Description: Erection of detached double garage

Location: 67 Peterborough Road
Crowland

Amendment: Garage moved 1 metre closer to highway
(dwg. no. 11.011A)

PLANNING: 67 PETERBOROUGH ROAD, CROWLAND - DETACHED GARAGE
REF: H02/0394/11

Drawing Number:
11.011 A

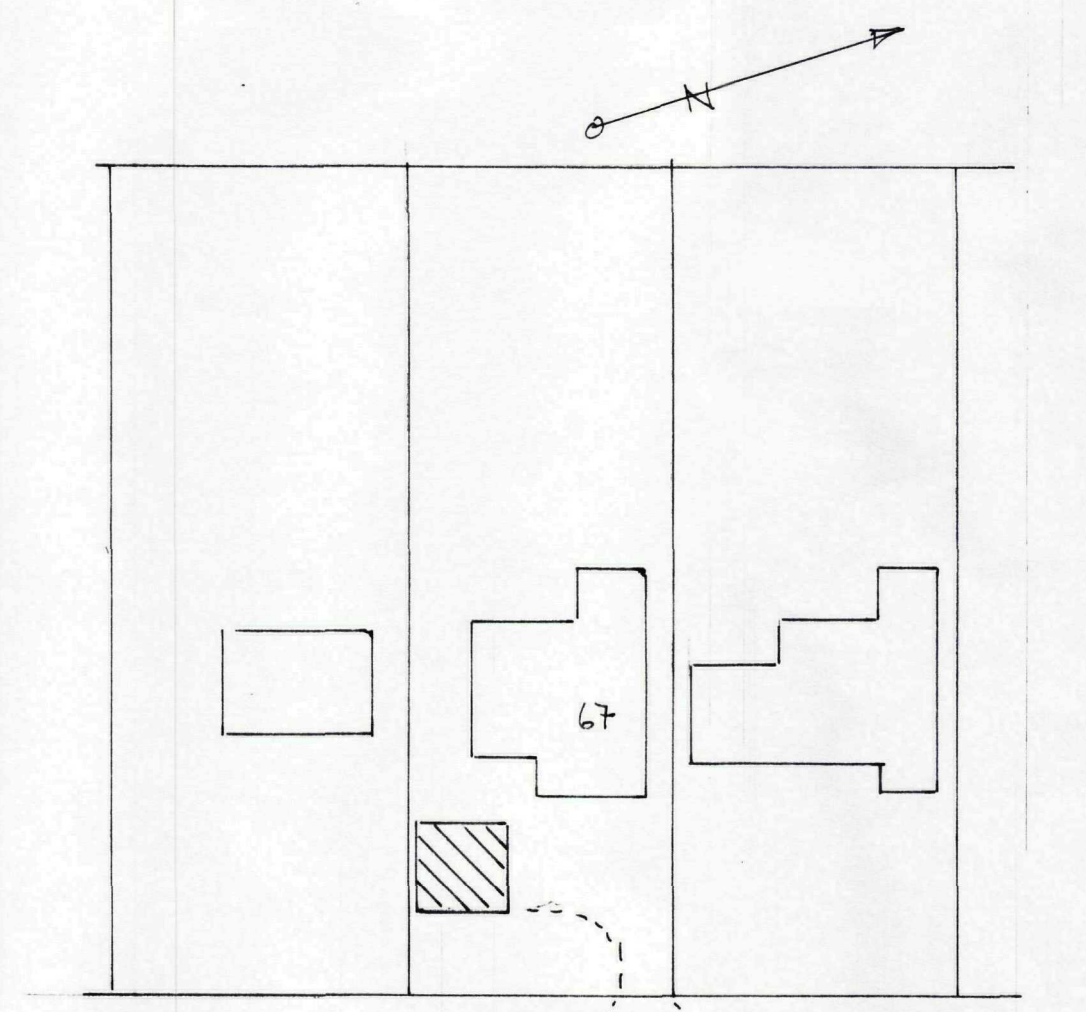
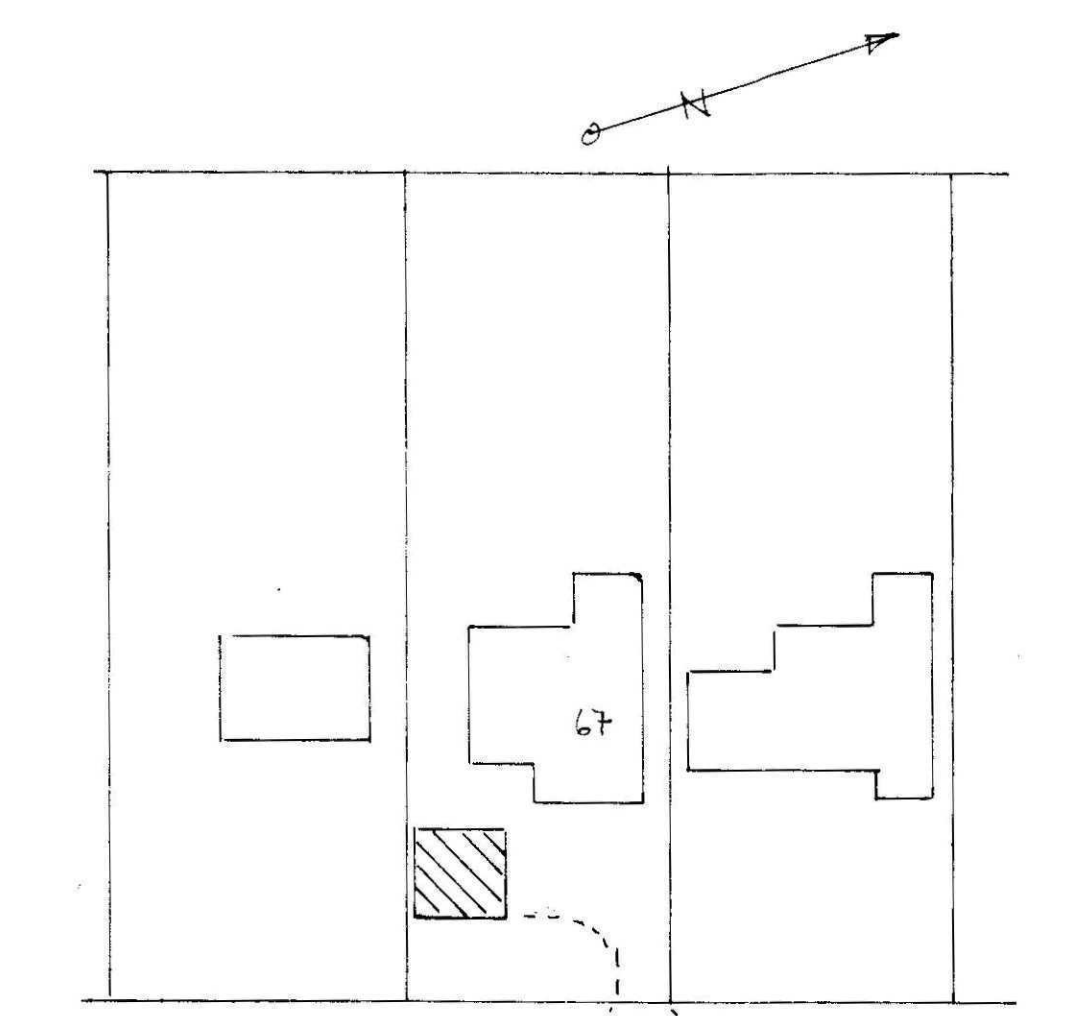
Garage moved 1.00m closer to the highway.
